**Crime Prevention Through Environmental  
Design (CPTED)**  
**AUDIT REPORT**

**112/134 Nelson St**

**July 6, 2023**

### **CPTED AUDIT: 112/134 Nelson St**

LEVEL 1

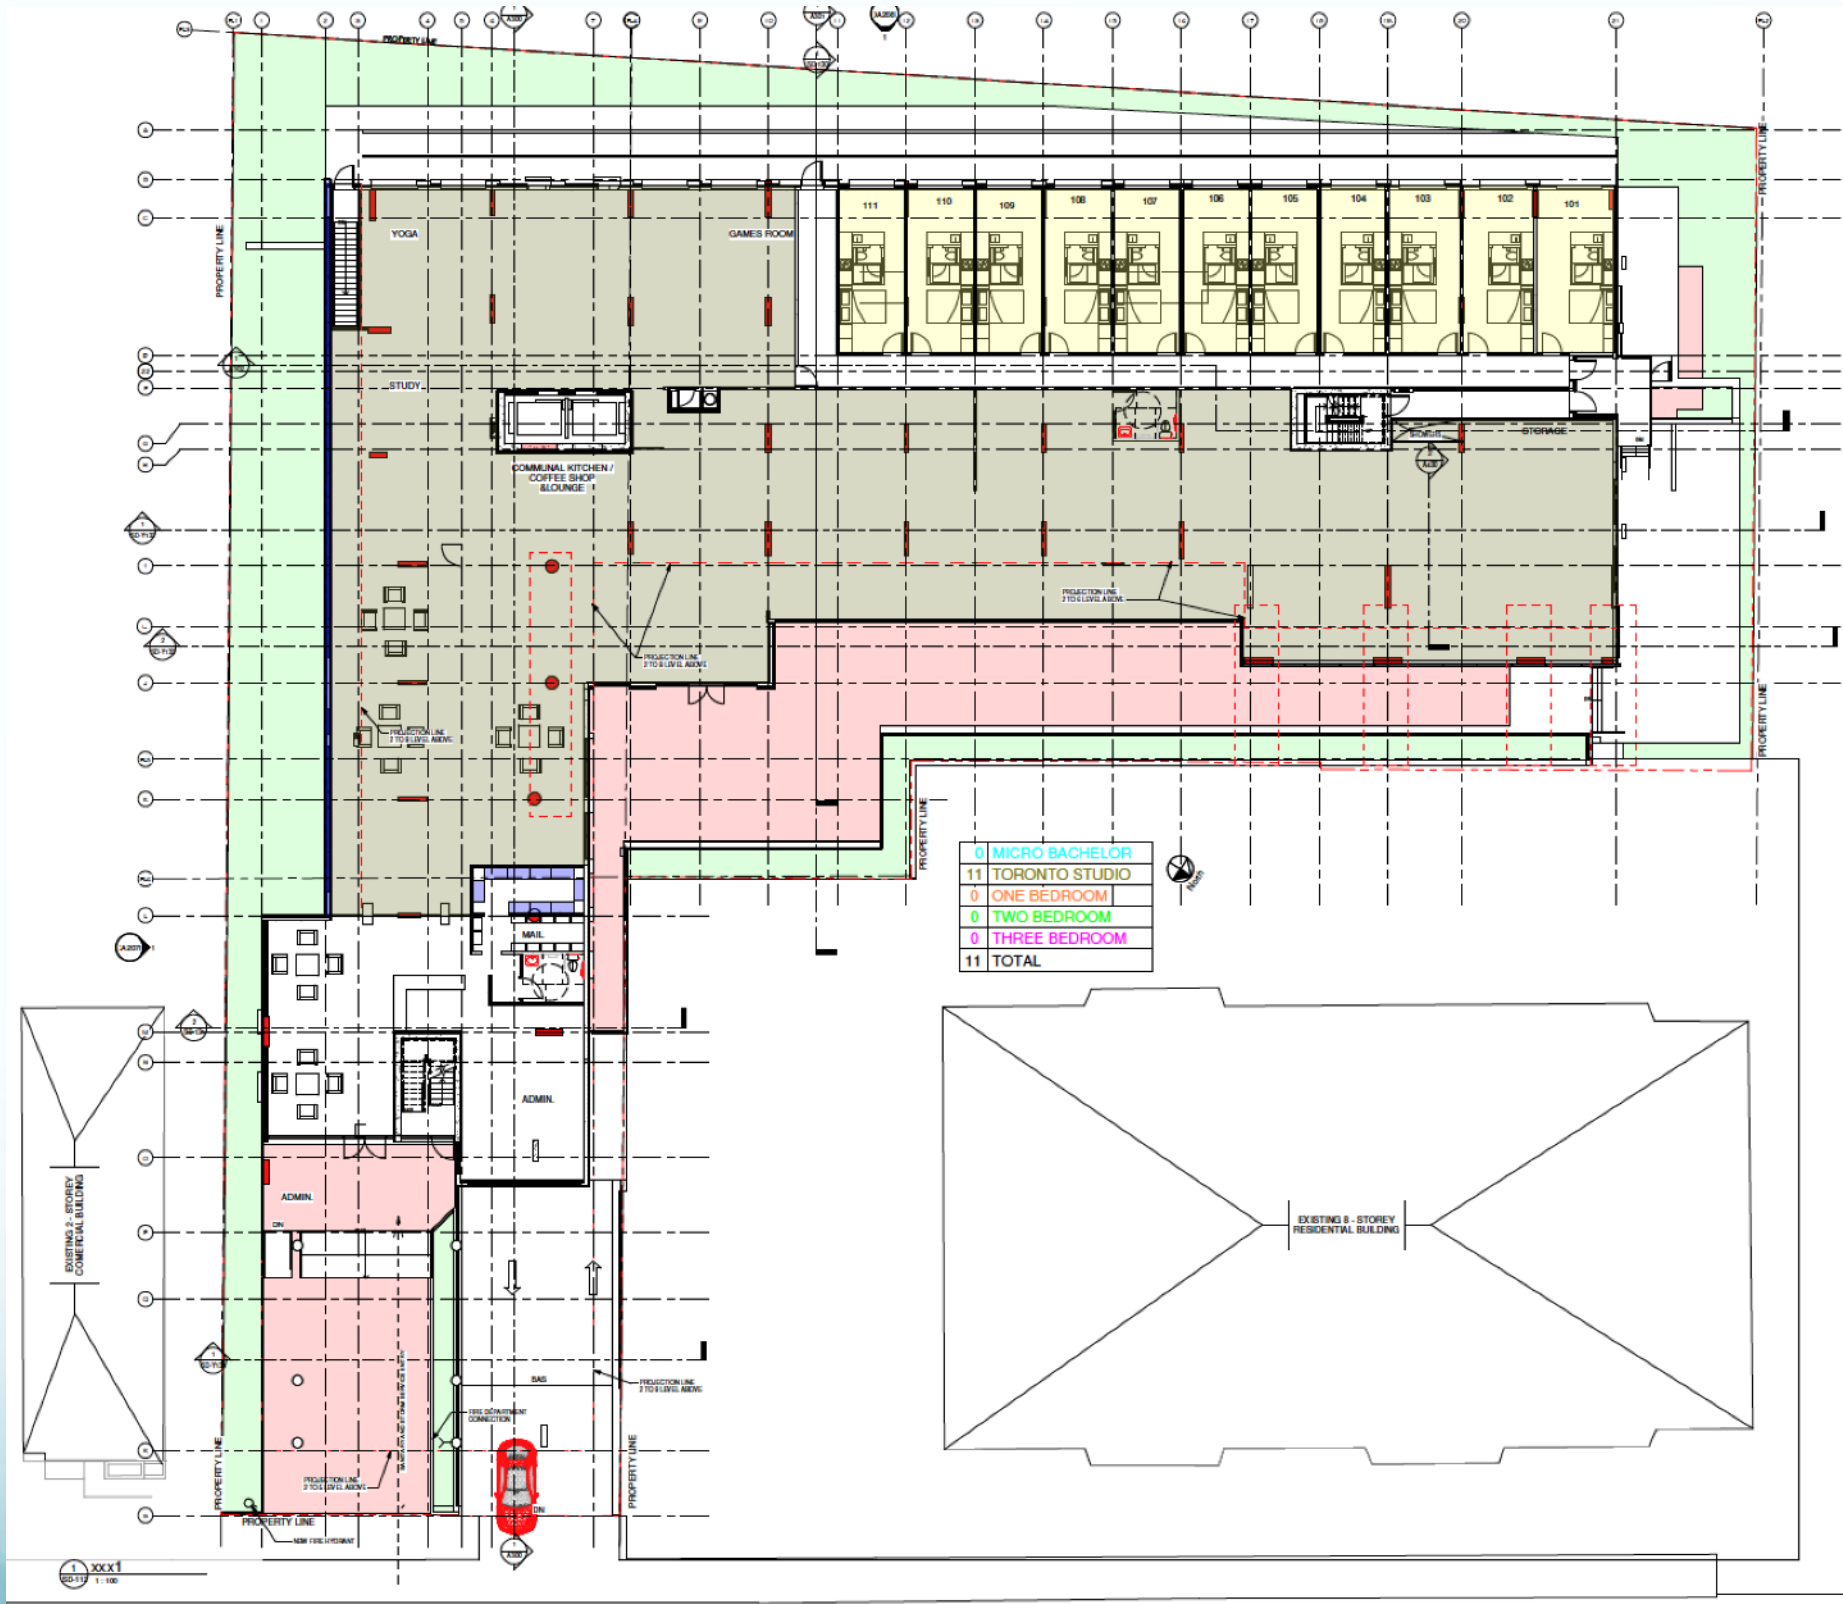
Post-Construction- The lobby, mail room and parking ramp are currently proposed for the front of the building. It would be great to consider locating some of the interior amenities to the front of the building as well to increase sightlines and “eyes on the street.”
